Online Comment

Application H03-0910-26
Location Bankhouse Farm The Delph Pode Hole PE11 3JH
Proposal Erection of replacement wind turbine

Name National Grid Electricity Distribution
Address formerly Western Power Distribution

Drawing
Proposed Site and Location Plan - A1

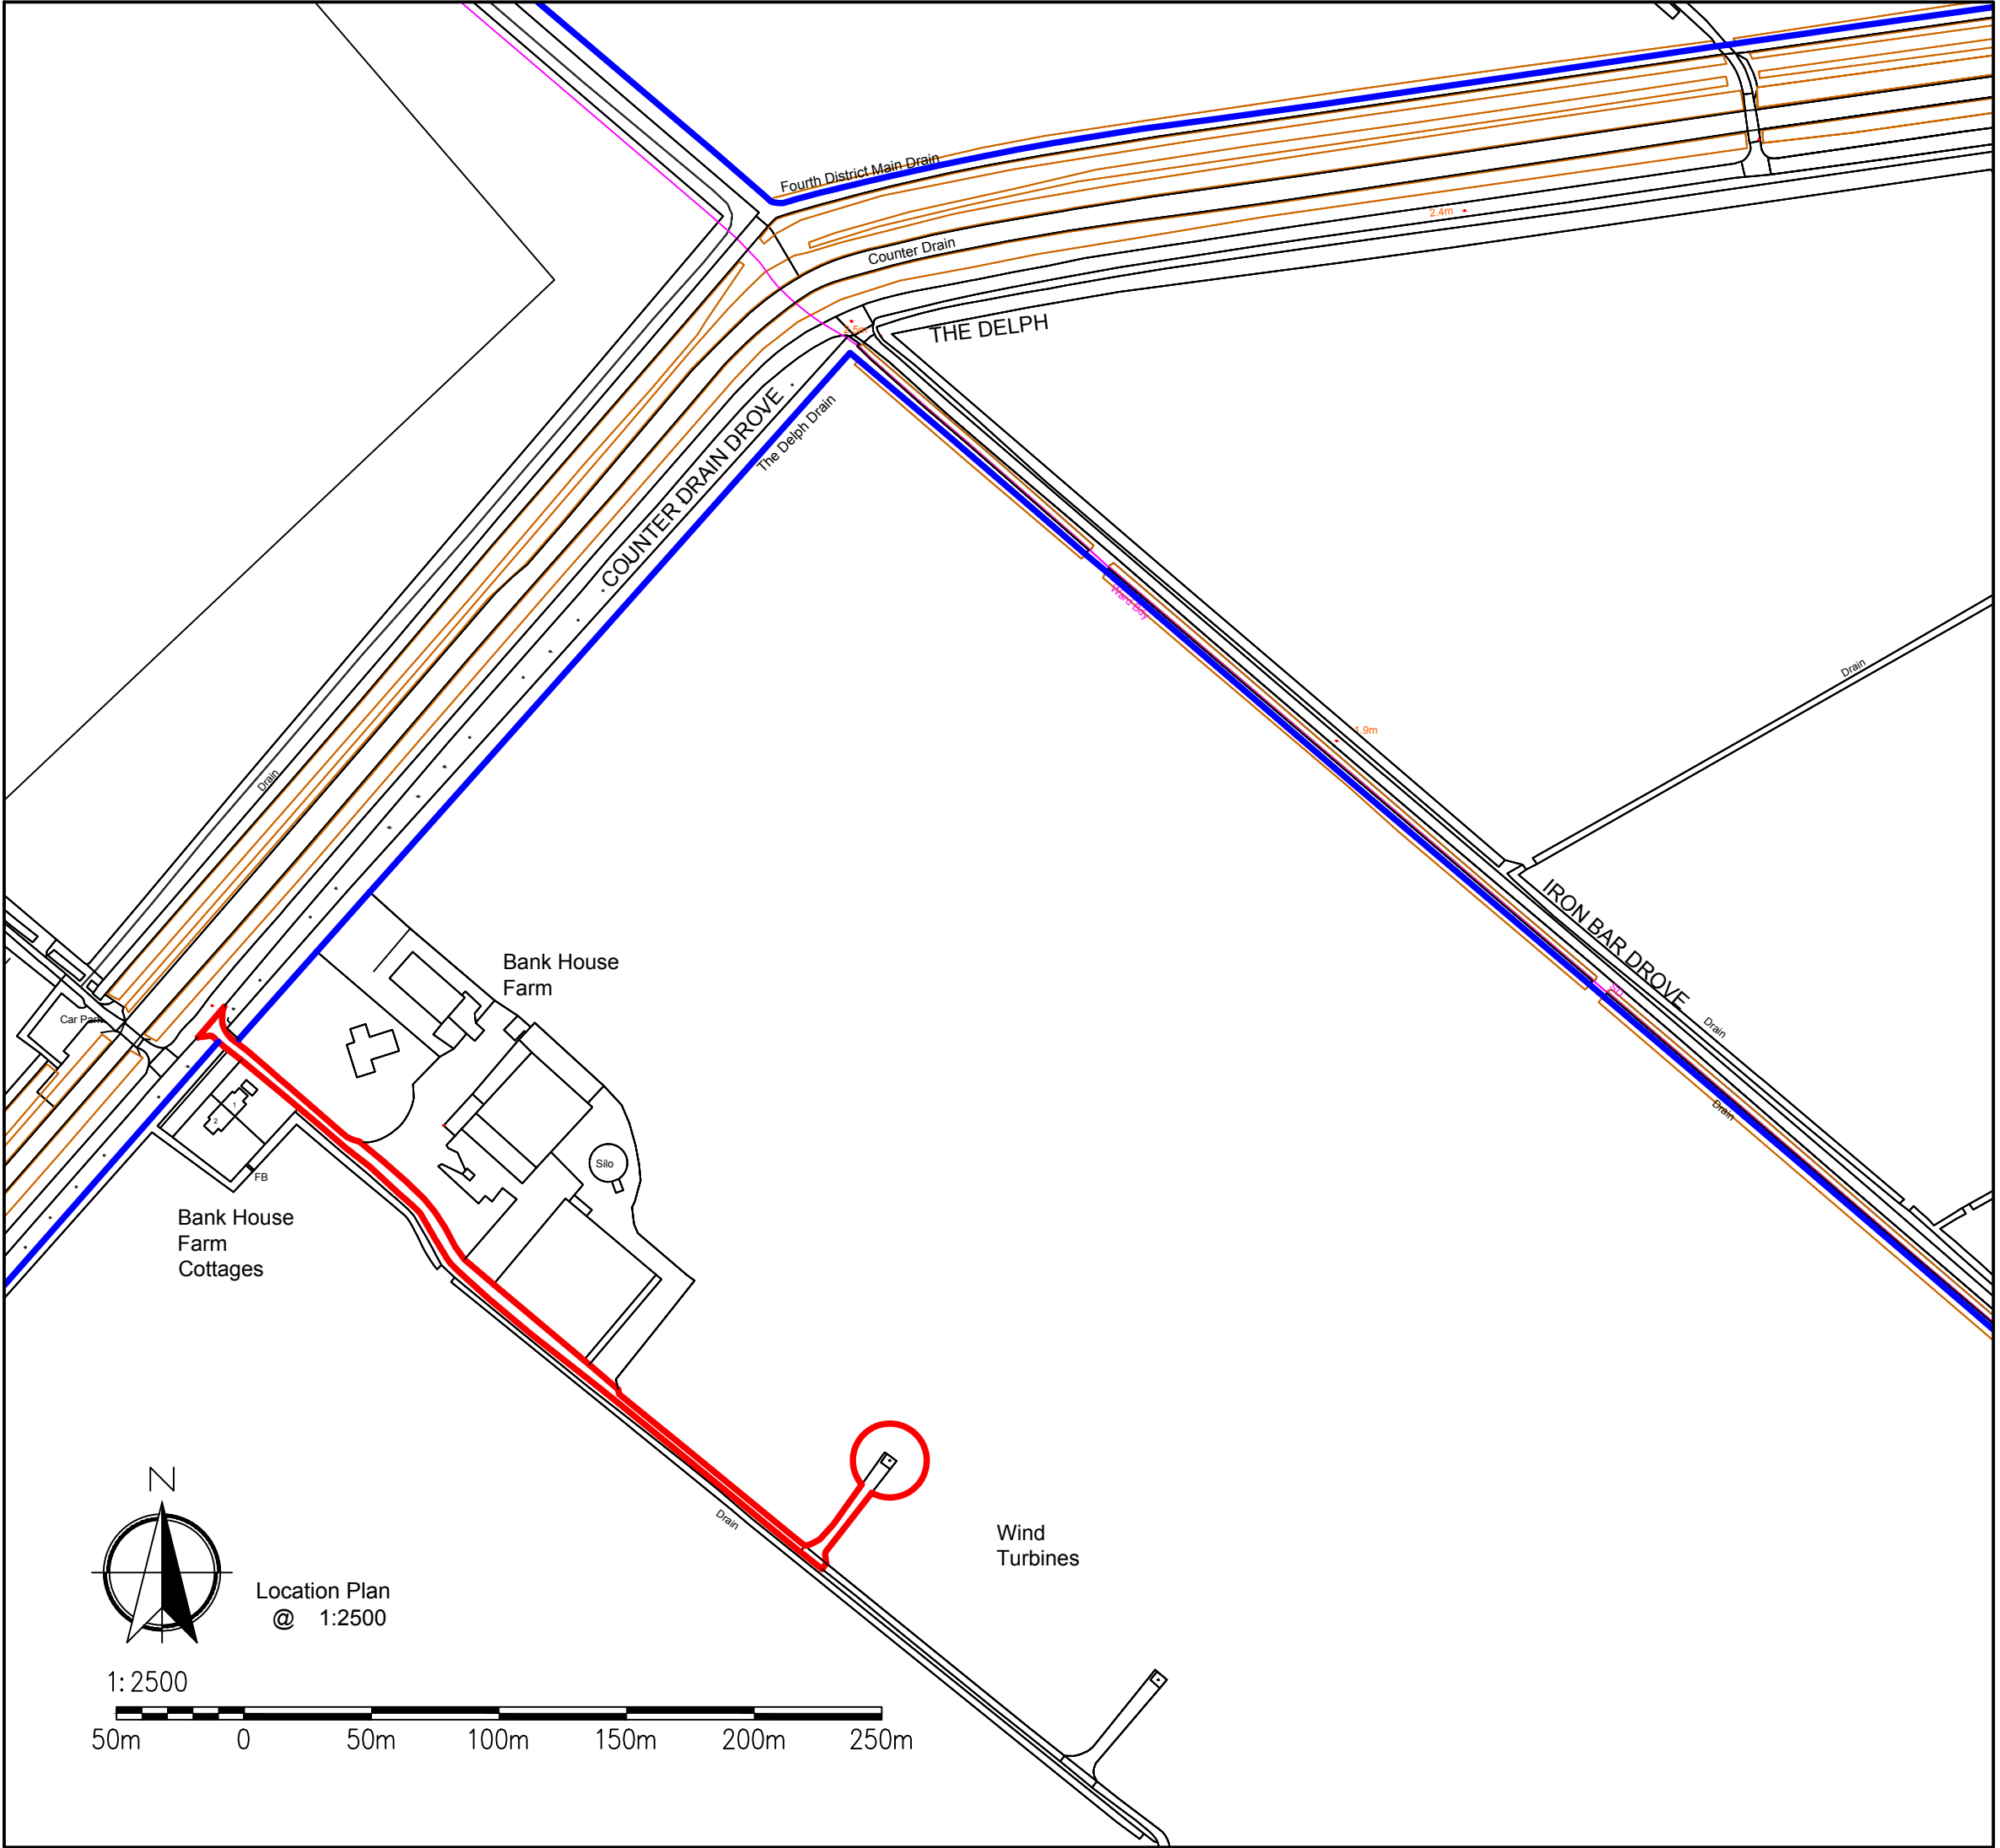
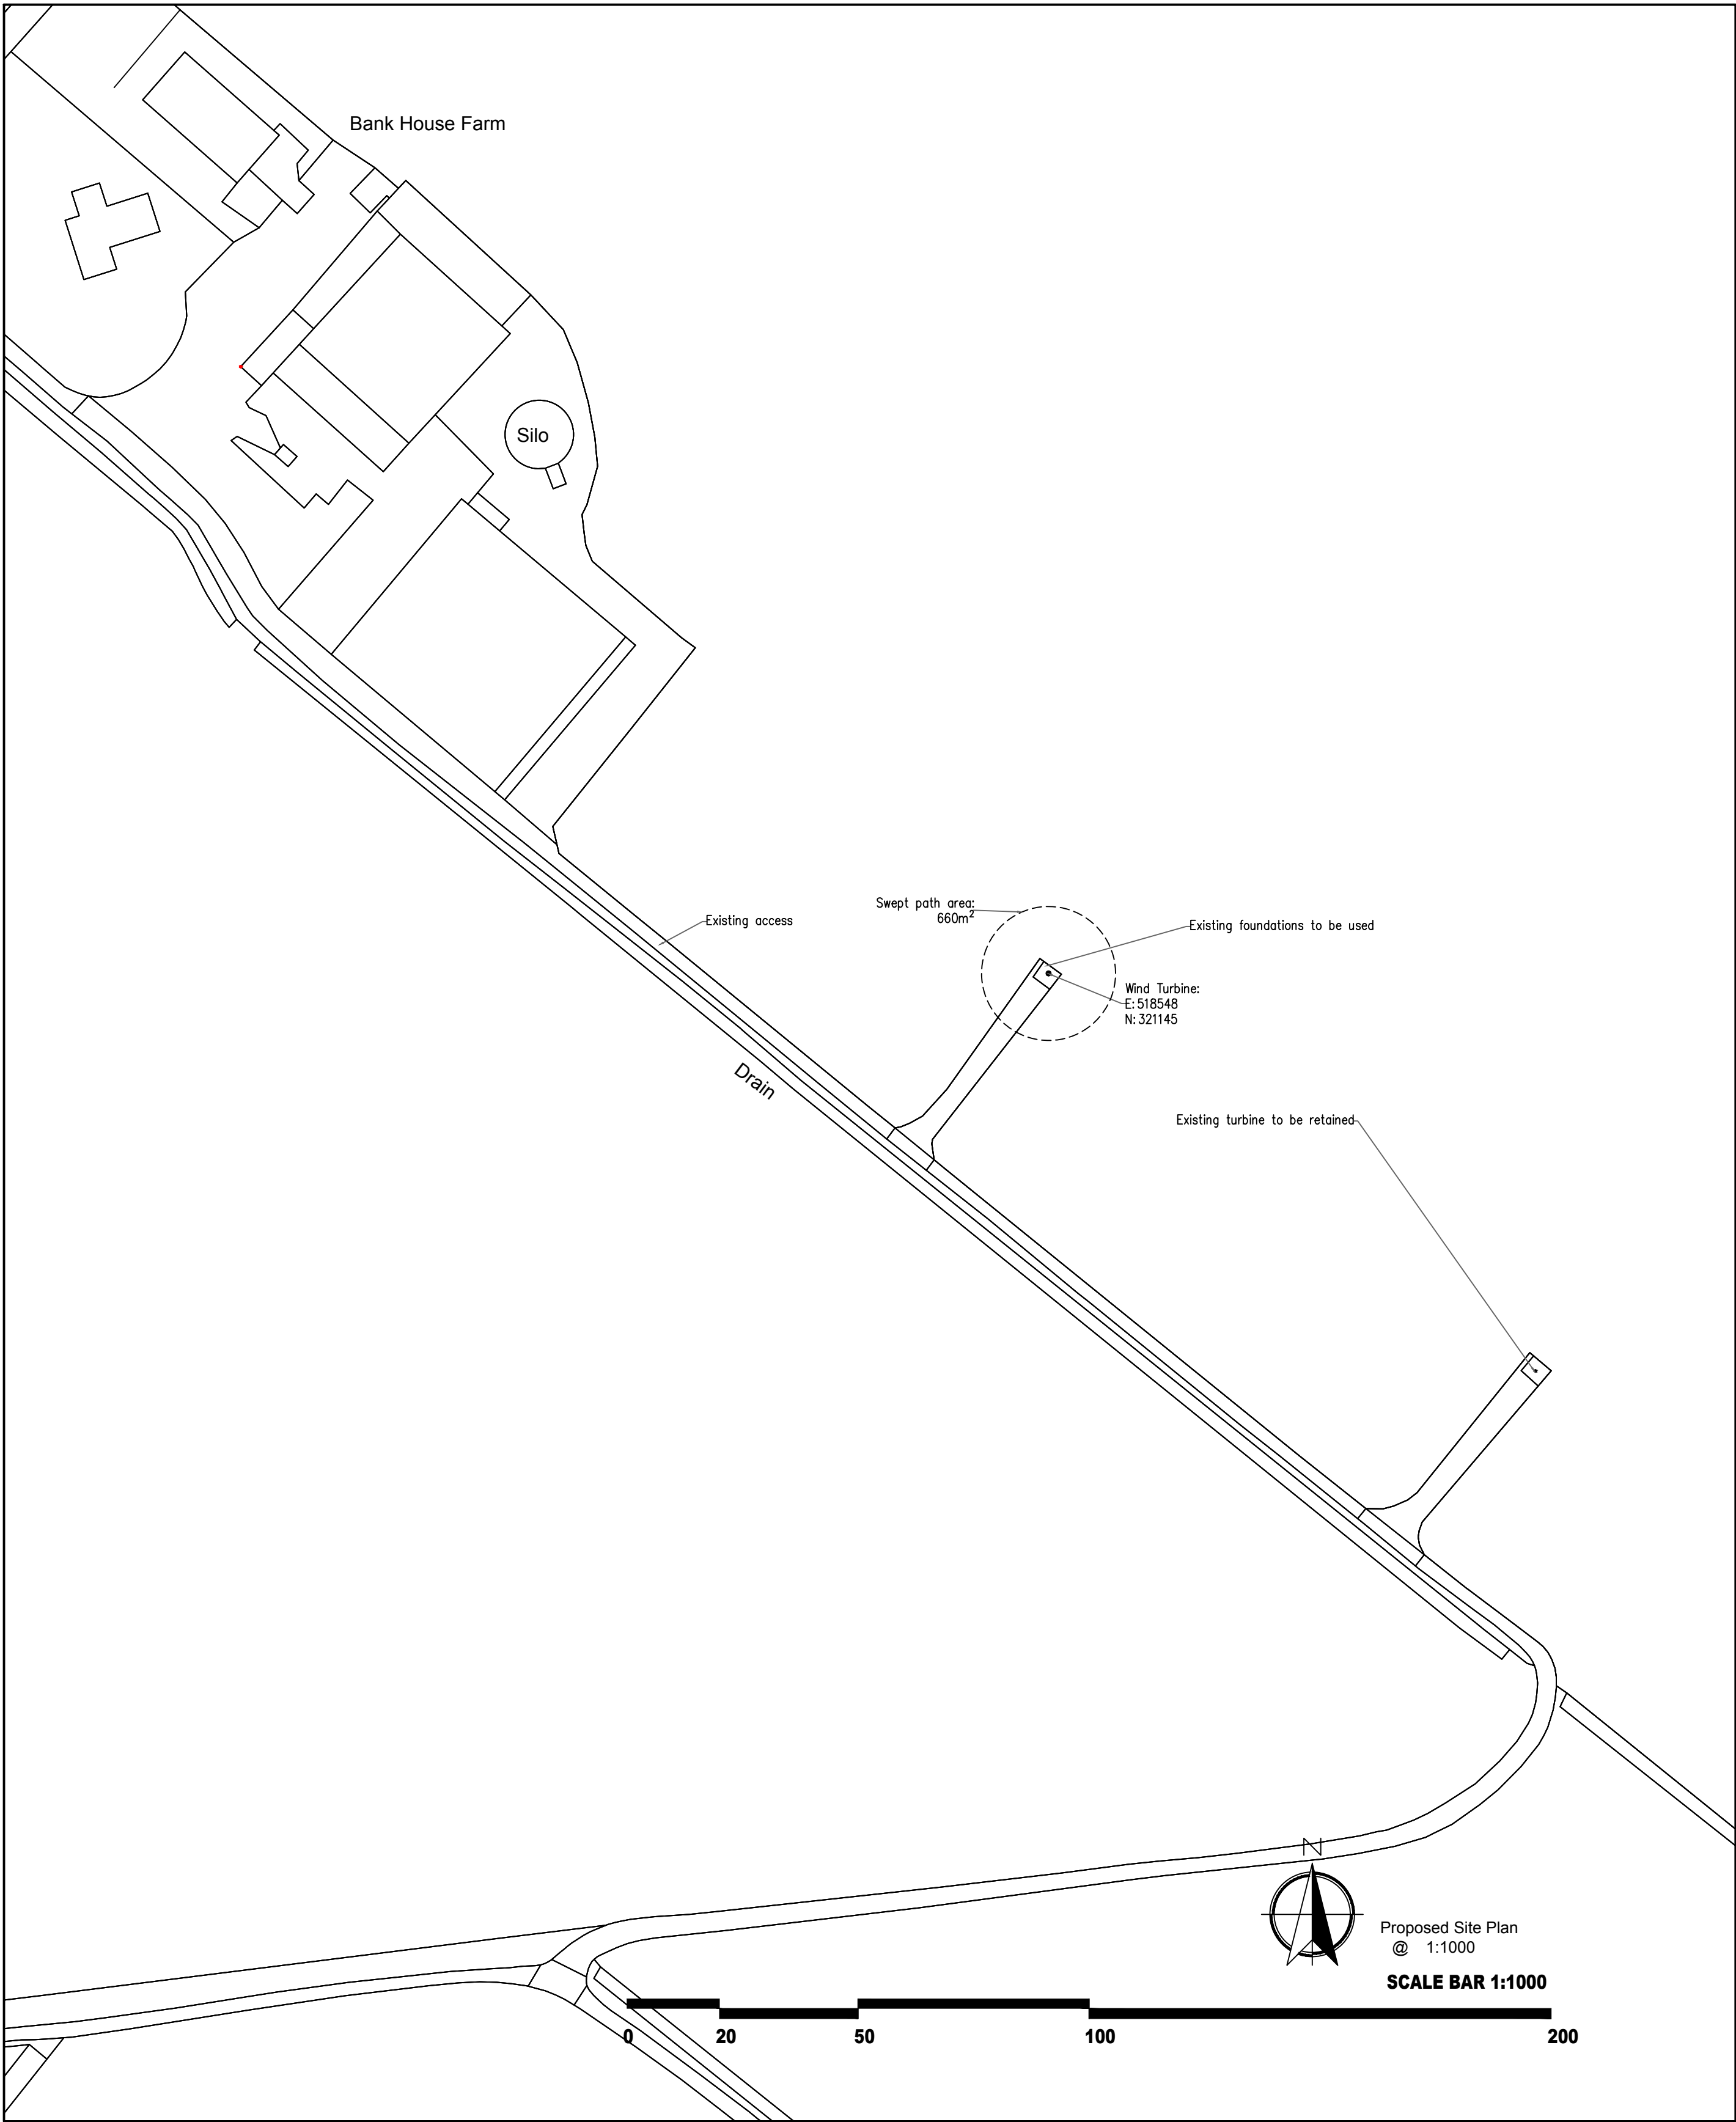
Please contact NGED if you have any concerns regarding the 11kv overhead line over the road, the line cannot be shrouded.
